Recommendation Report for Planning Permission for Works or Extension to a Dwelling

REF NO: R/35/20/HH

LOCATION: 4 Copper Hall Close
Rustington
BN16 3RZ

PROPOSAL: Single storey rear extension.

Proposed Elevations

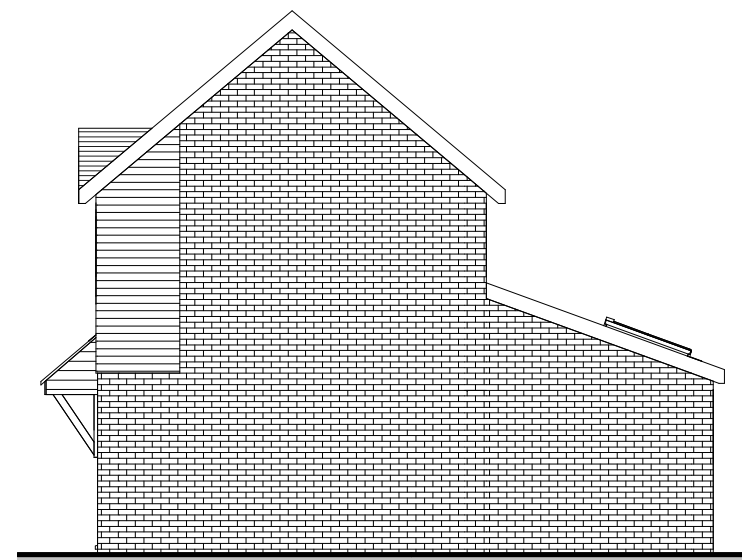
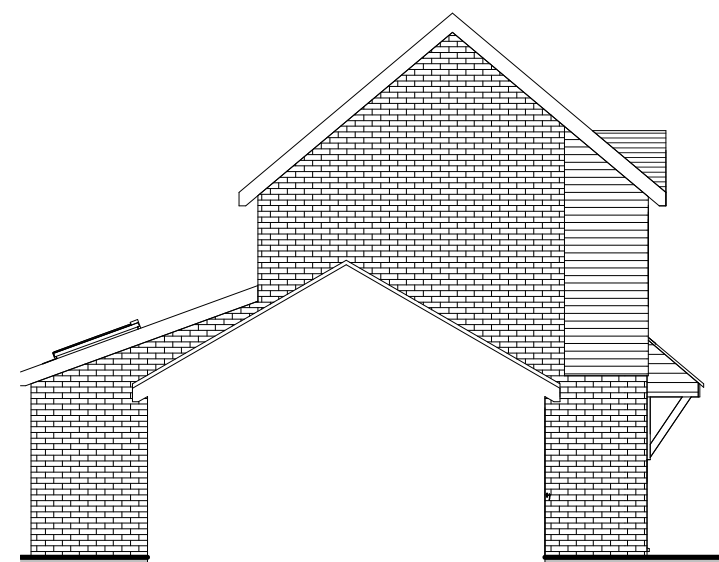
The proposed development will be visible from the street scene due to its height, however, it is not considered to result in any significantly harmful impact upon the character of the locality. This is largely due to the design of the proposal, and the use of materials to match. Whilst the scale of the proposal means that it does not appear subservient to the host dwelling, the use of materials and its siting is considered to allow it to be sympathetic to the character of the host dwelling.

The proposal will be visible from the street scene. However, the proposal is not considered to result in a significantly harmful impact upon the host dwelling, or the locality in order to prescribe refusal of the application. Therefore, whilst the application is in conflict with D DM4(b) of the Arun Local Plan, it is in accordance with D DM1 and D DM4(a) of the Arun Local Plan.

Floor Plans

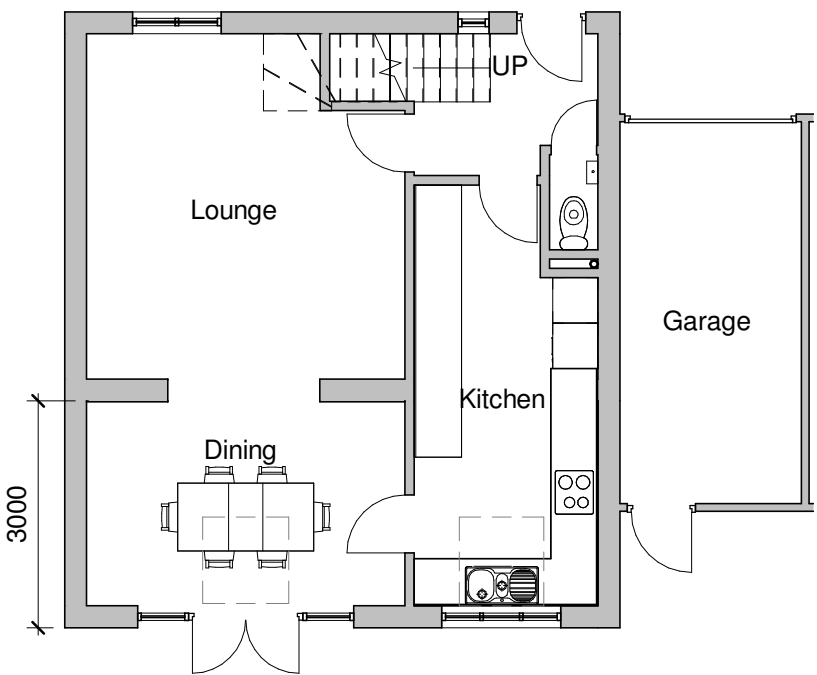
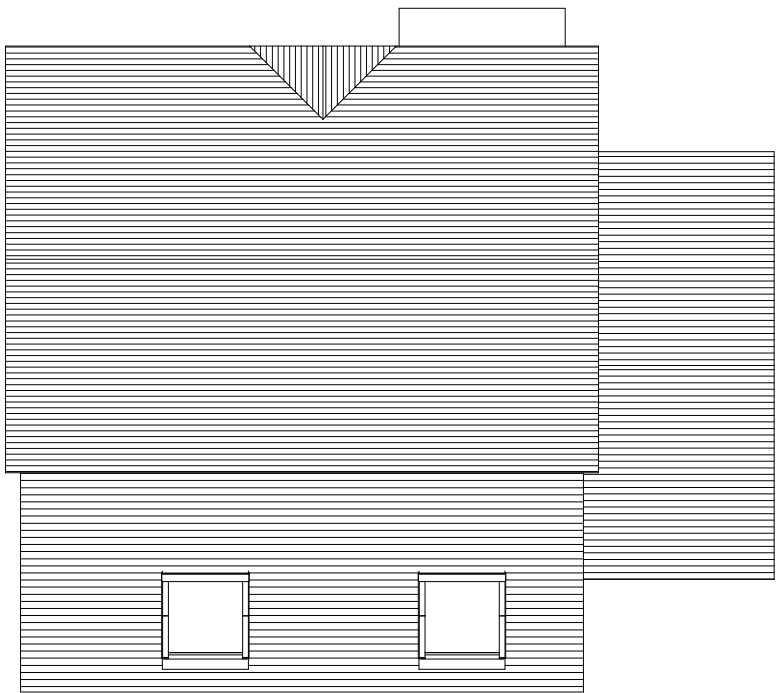
The proposed development is not considered to result in any significantly harmful overshadowing or overbearing impact upon the occupiers of neighbouring dwellings. This is due to the separation distance of 2.2m between the extension and the Northern application site boundary and the boundary treatment between the dwellings mitigating any significantly harmful impact. With regard to loss of privacy, the proposed development is single storey in its nature, and as such, does not provide any views that are not available from the application site at current.
